From: "Rebecca Eveleigh" <reveleigh@kmc.nsw.gov.au>
To: "Mark Brown" <Mark.Brown@planning.nsw.gov.au>
CC: "Walter Gordon" <walterg@meriton.com.au>, "Kathy Hawken" <khawken@kmc.nsw.gov.au>
Date: 9:36 am 19/09/2011
Subject: MP 10_0057 MOD2 - amendment to Condition 35, 132-138 Killeaton Street, St Ives - Council submission

RE: Modification Application MP10_0057 MOD2 - Amendment to Condition 35 (de-watering requirements)

Modification application not supported

PLANS OF THE PROPOSED BASEMENT
(supplied courtesy of Meriton Apartments Pty Ltd)

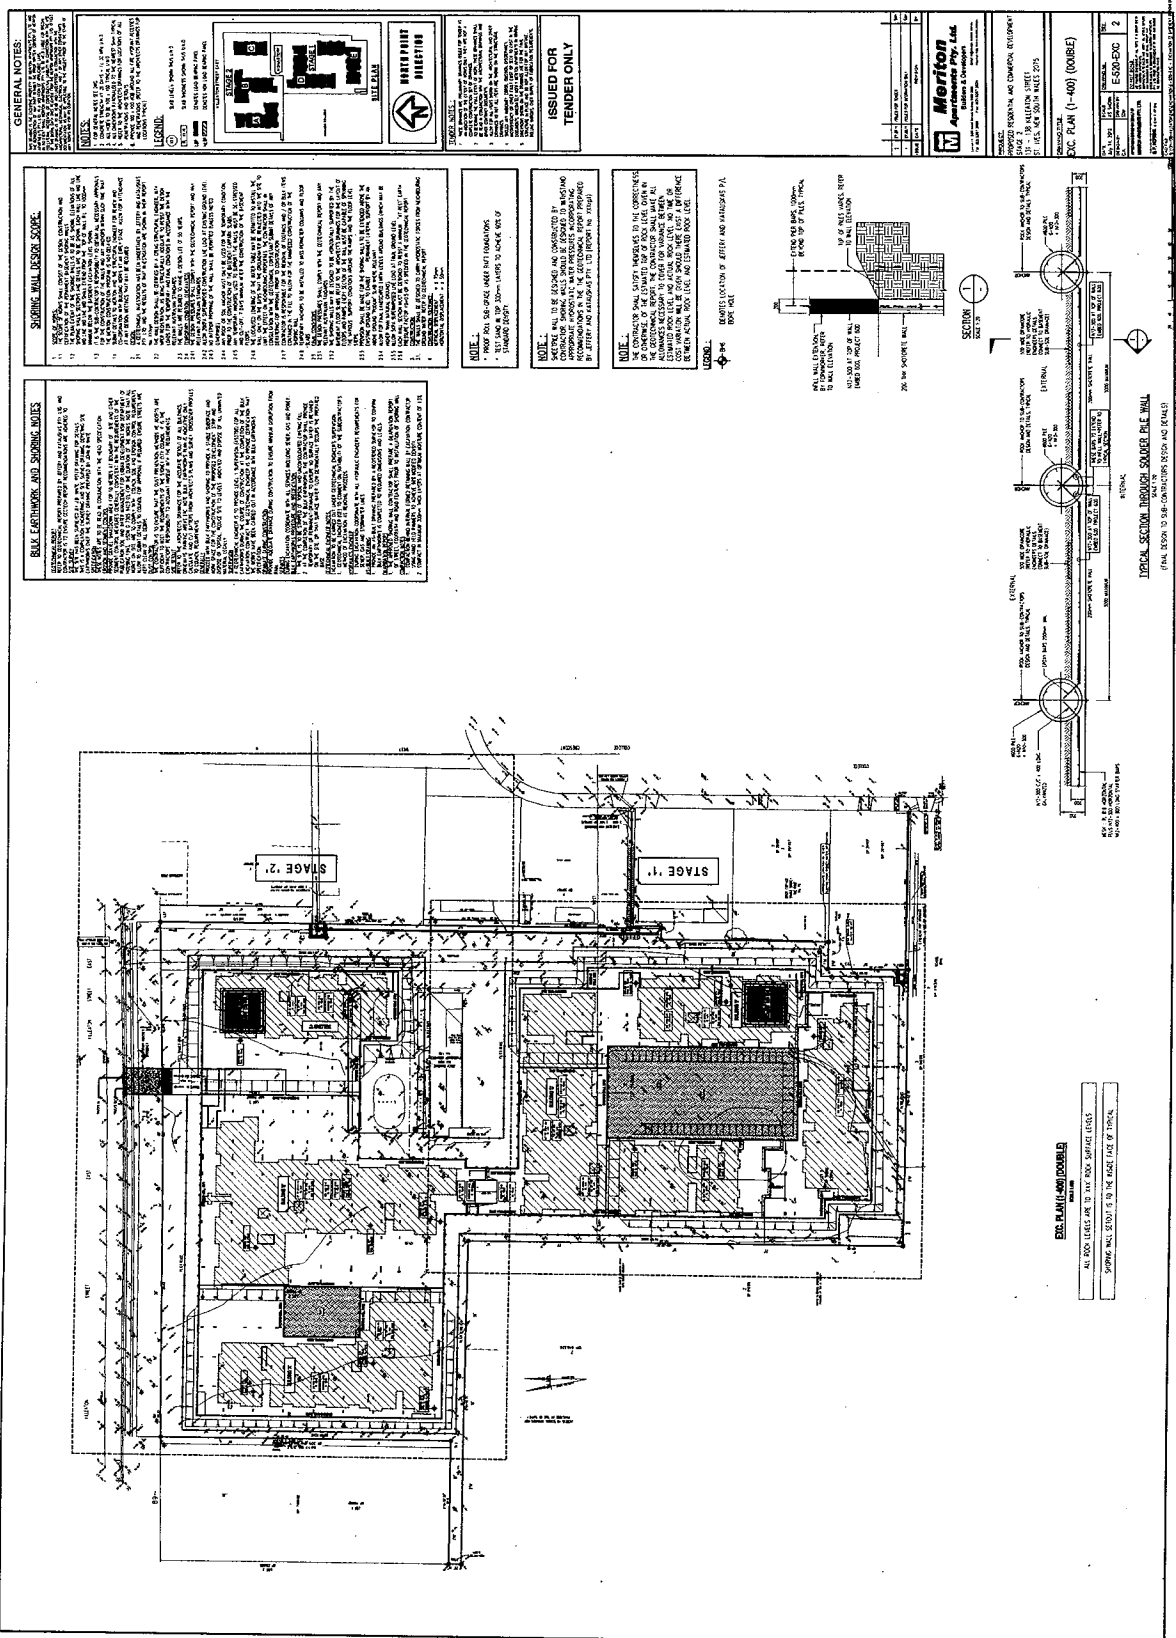
Section 4.3 of the report by Hayes states "Plans for the proposed basement are presented in Appendix A". At A4 size, these plans are illegible. The last page seems to show a pump pit in the basement and an oil separator hand-drawn onto an architectural plan.

The size, capacity and model of the oil separator are not given and nor are details of how this will be maintained by the Owners' Corporation.

SITE SURVEY PLAN WITH THE PUMP OUT DISCHARGE POINT
(supplied courtesy of Meriton Apartments Pty Ltd)

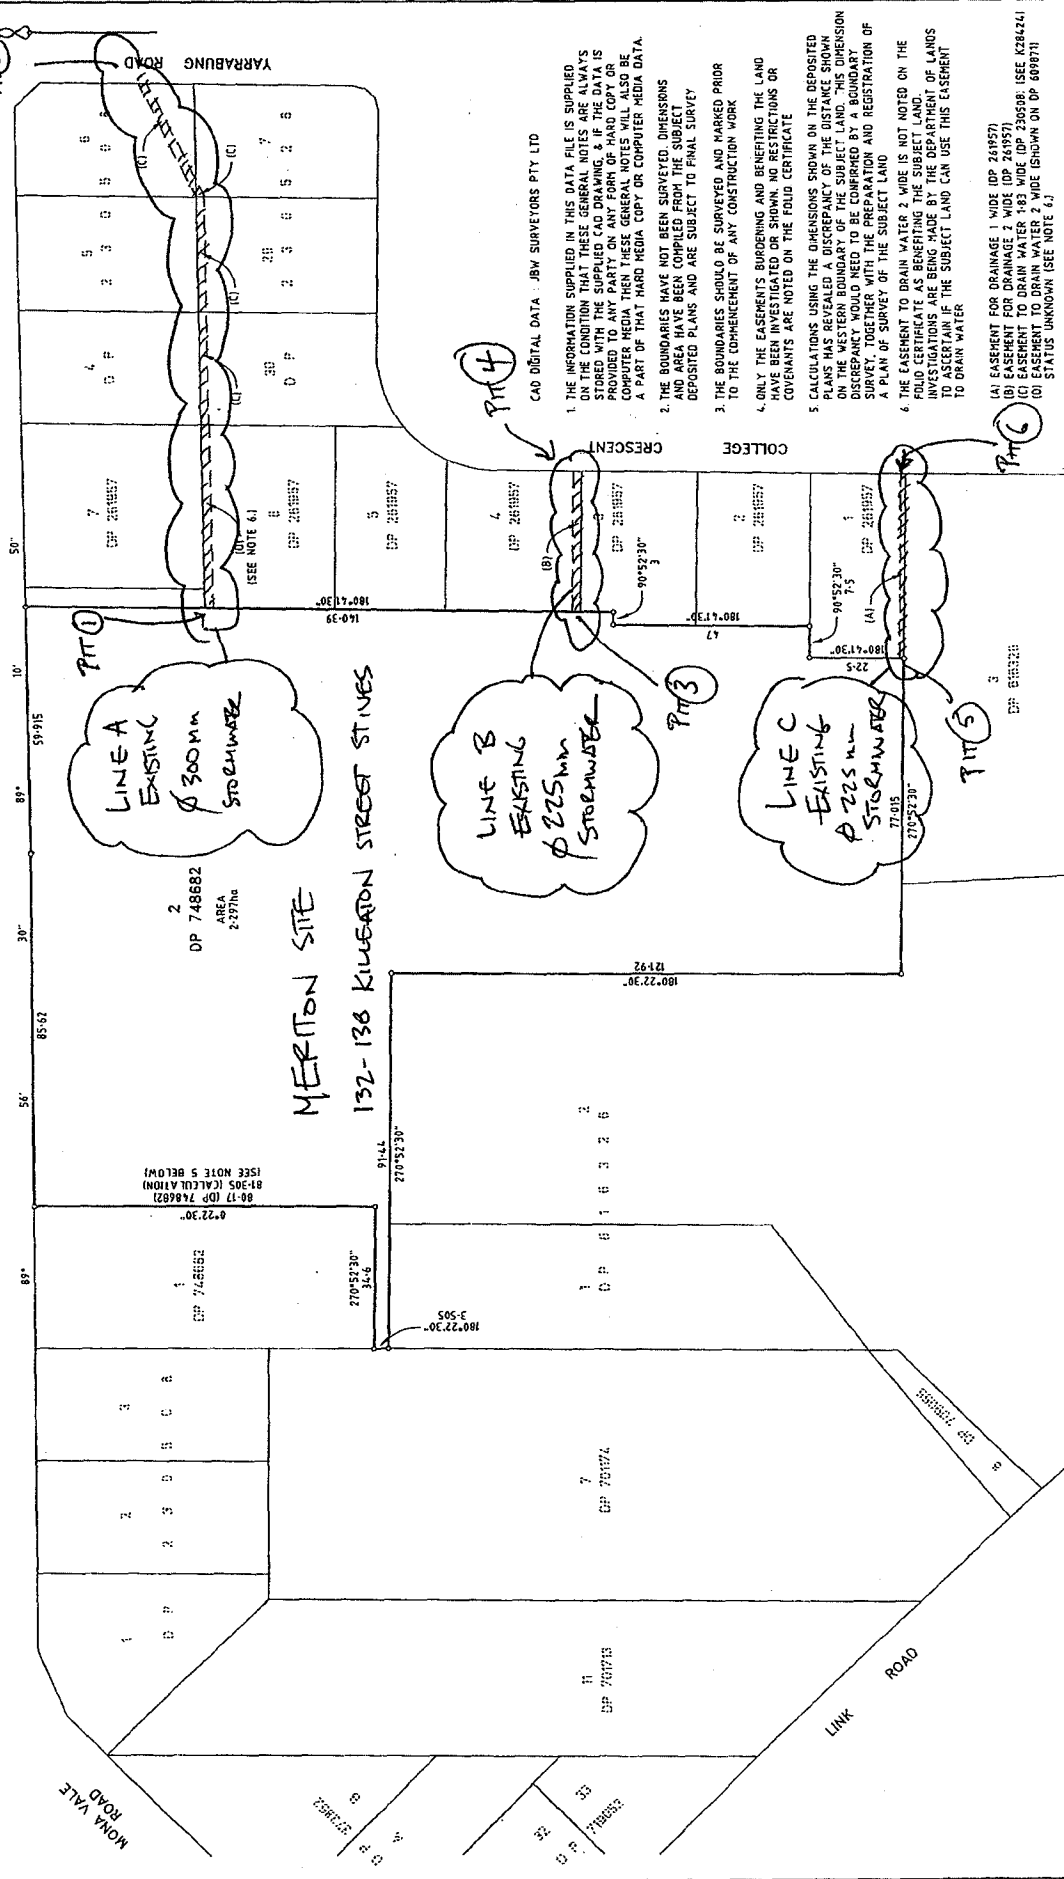
The interallotment drainage pipe through the downstream properties is already at capacity and additional flow should not be directed into it, particularly because the pipe is most likely to be running full at the same time as the most seepage into the basement is likely to occur.
